Address: 9 Bradley Grange Gardens Huddersfield Hd21qx

Application number: 2024/91912	
What is the application for?:	Erection of front, side and rear extensions with extended dropped kerb and assoc
Address of the site or building:	7, Bradley Grange Gardens, Bradley, Huddersfield, HD2 1QX
Postcode:	HD2 1QX

Type of comment: An objection	
Do you wish your comments to be published on the website anonymously?	No

PROPOSED SIDE ELEVATION Scale 1:100

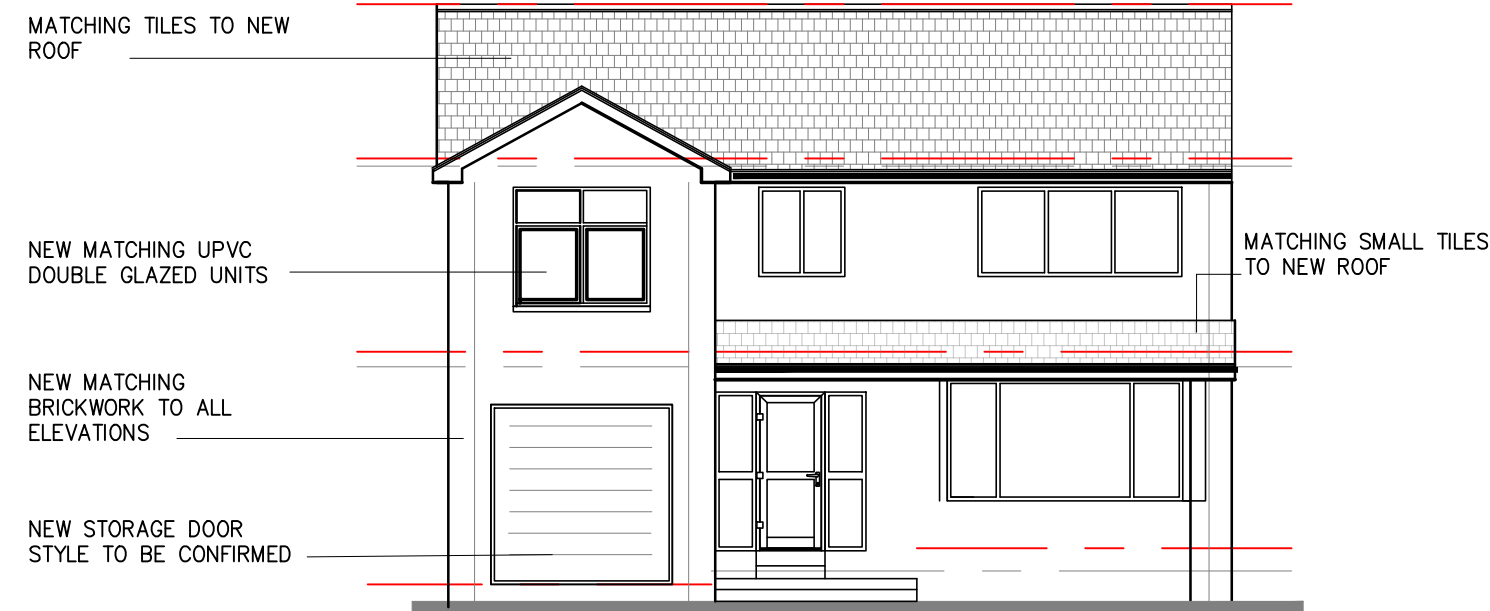
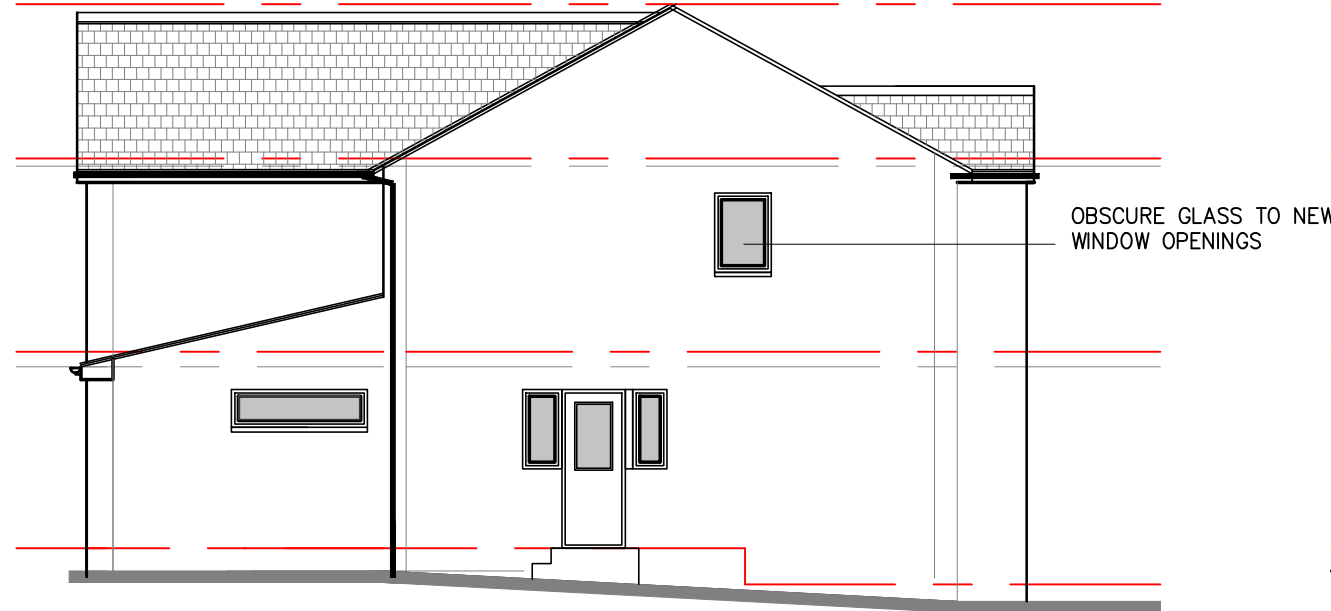
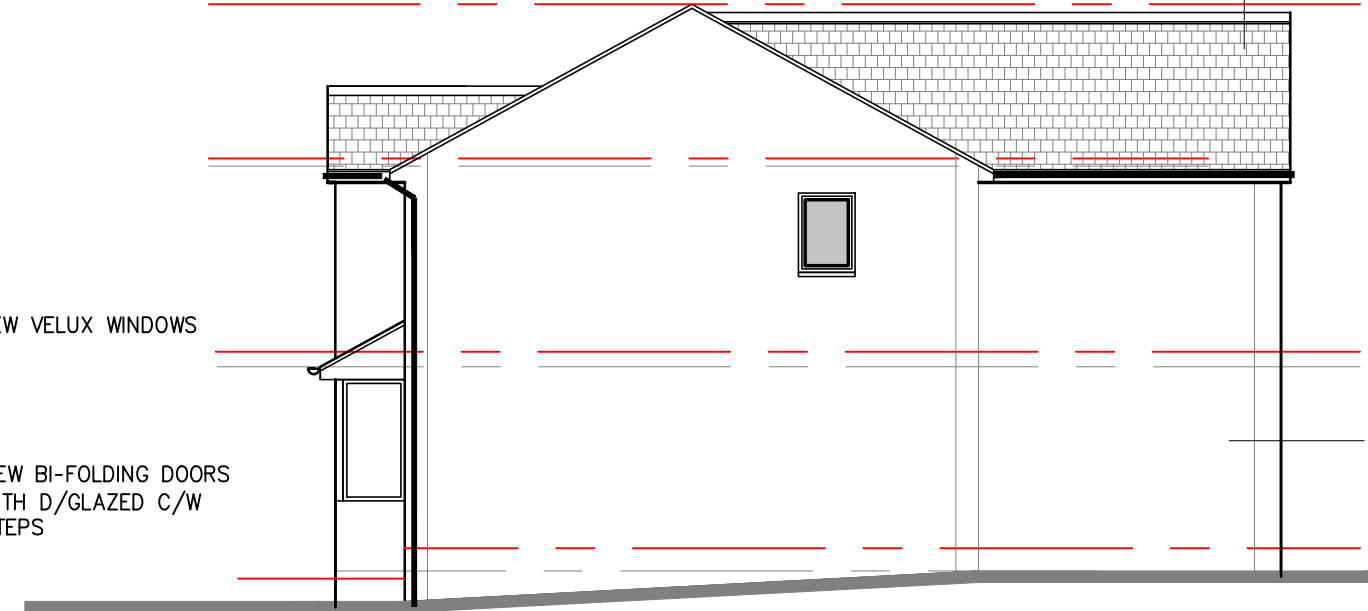
Our house, Number 9 has a neighbouring distance of 1.8 Meters from the below property number 7. The plans show a new bathroom window to be inserted to the right hand side of their property. This bathroom window will face directly into my bedroom window, which we are extremely uncomfortable about. Regardless of whether the glass is distorted or not.

Again with the houses been in such close proximity the new bathroom window has the potential to increase noise levels from their property to ours, having an effect on sleep quality

PROPOSED GROUND FLOOR PLAN Scale 1:50

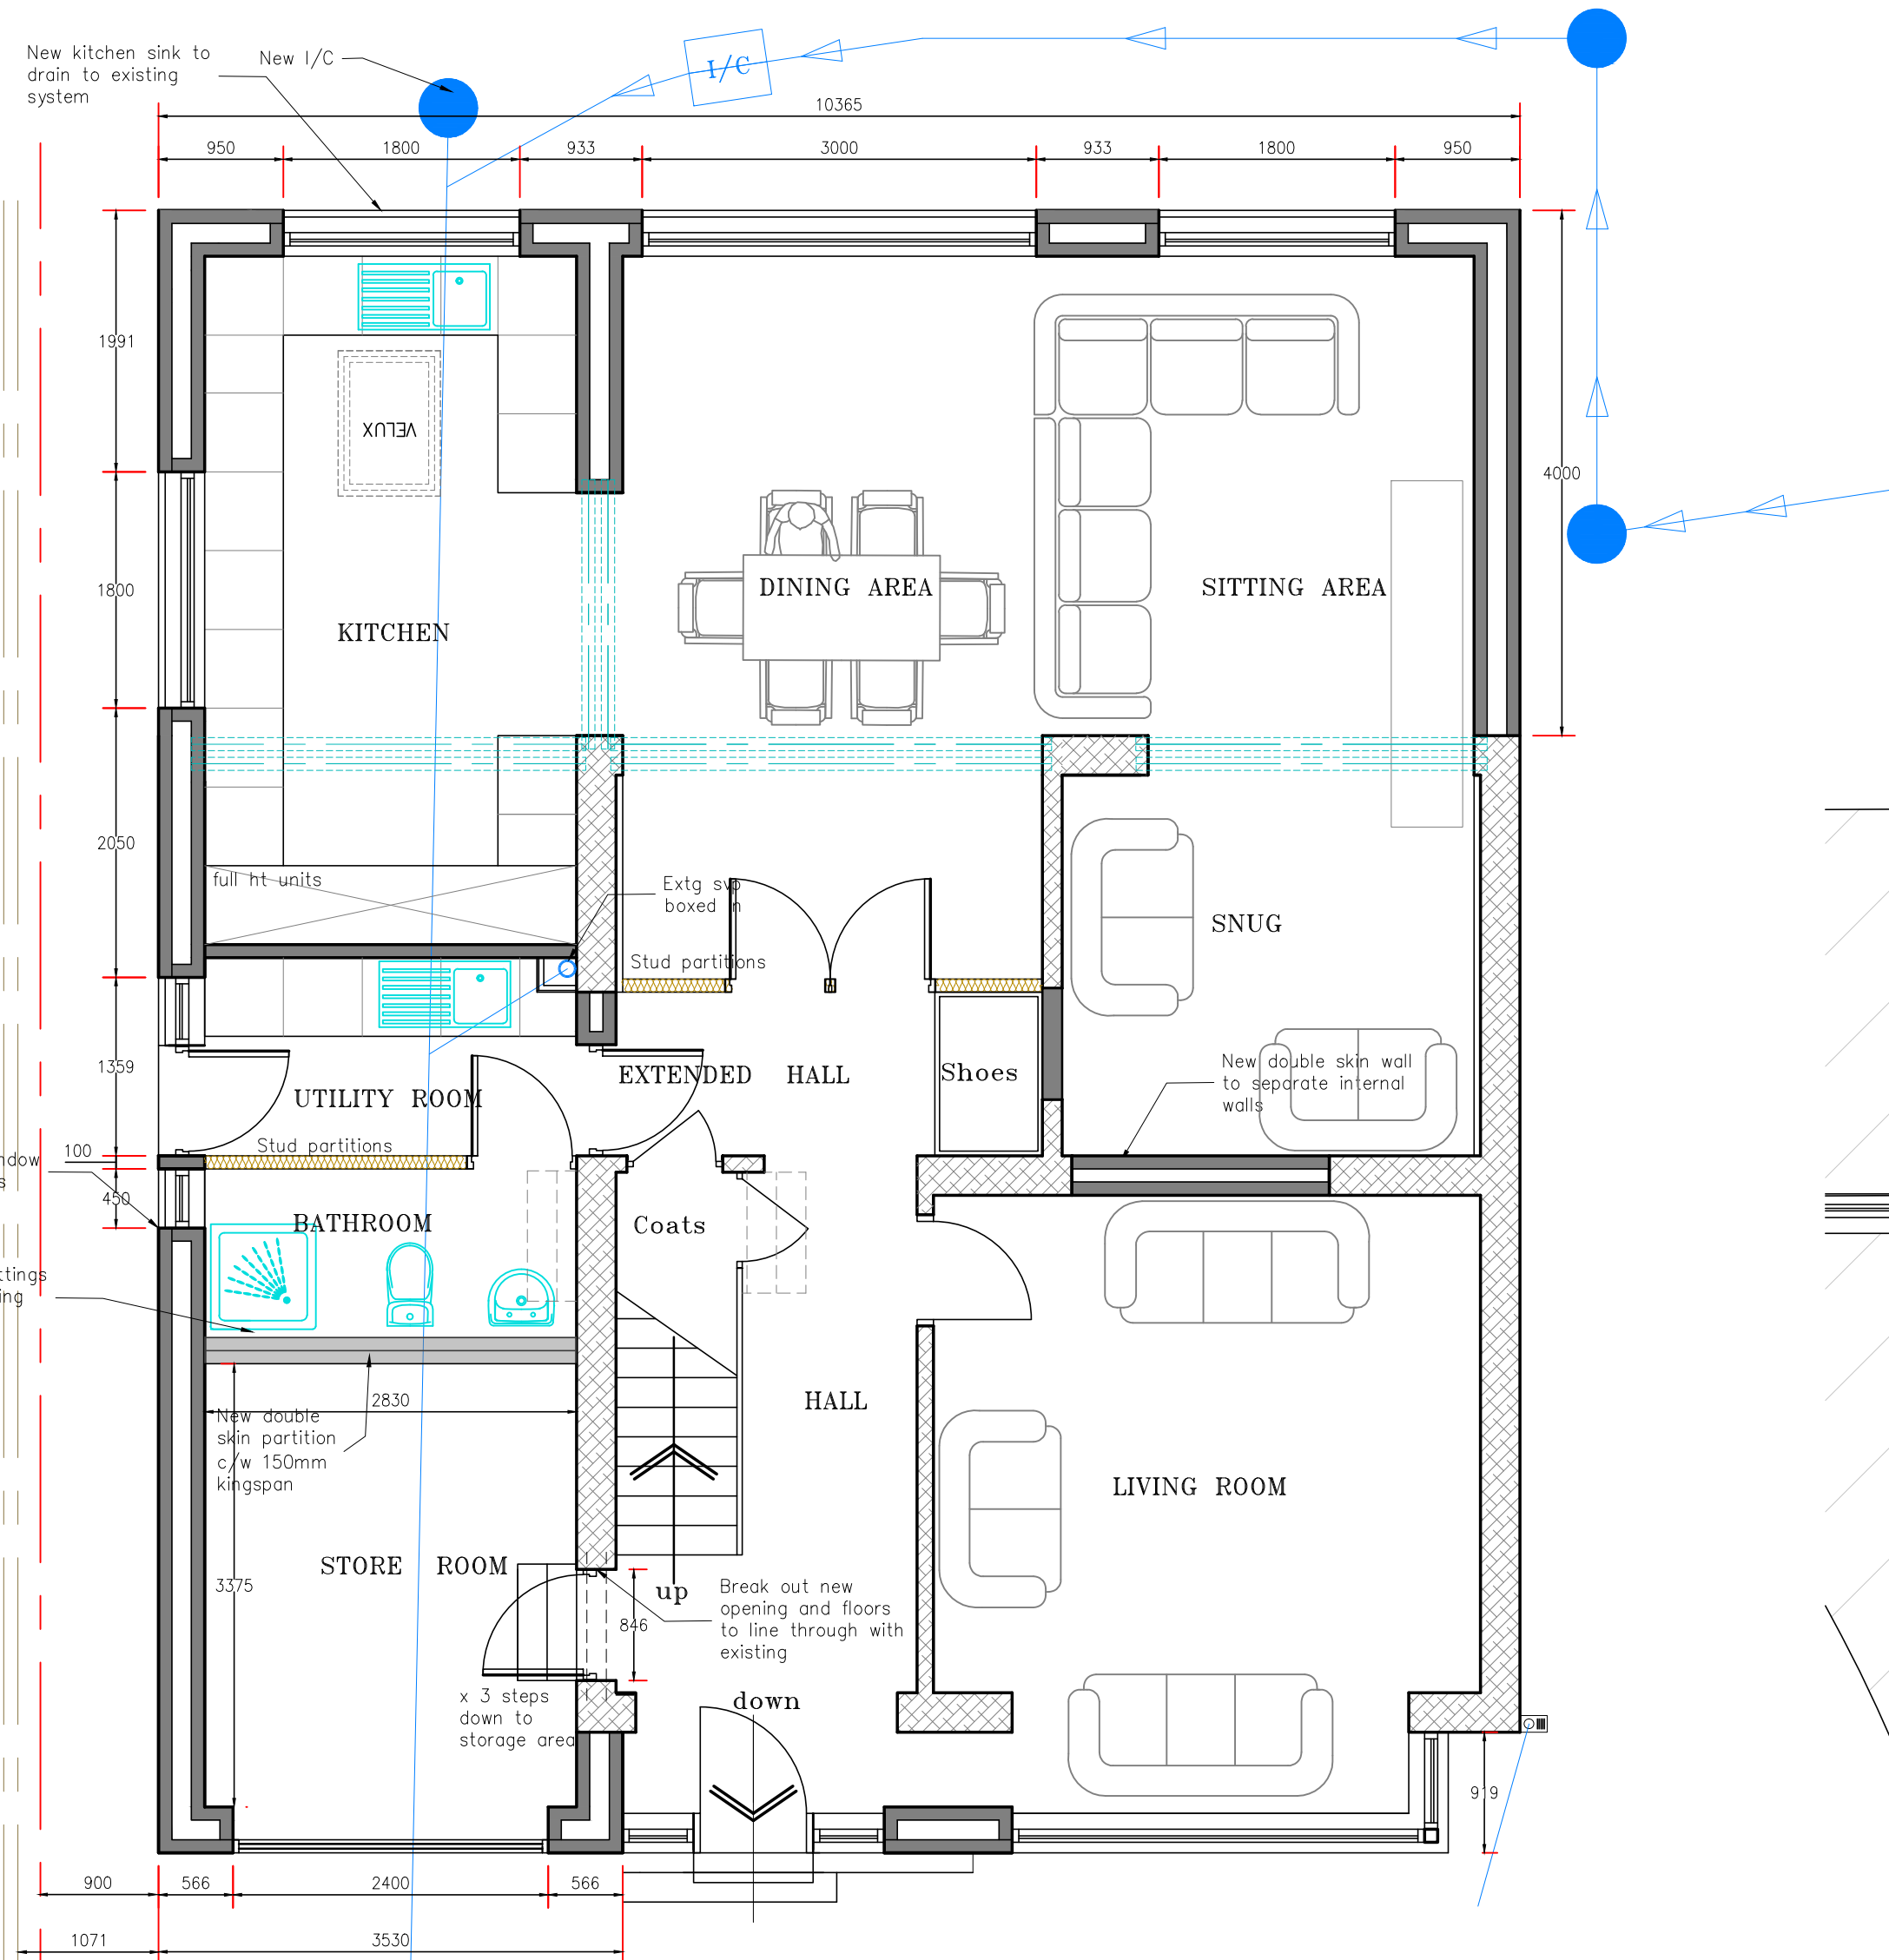
Our next concern is the redirecting of the sewage pipe that runs directly behind all the properties on Bradley Grange Gardens. These pipes are a frequent nuisance as they regularly become blocked and back up. In the 4 years we have lived here, there has been numerous issues with drains becoming blocked and backing up into our section of the pipe. The new bend in the pipe to work around the new extension could cause further issues with circulating waste.
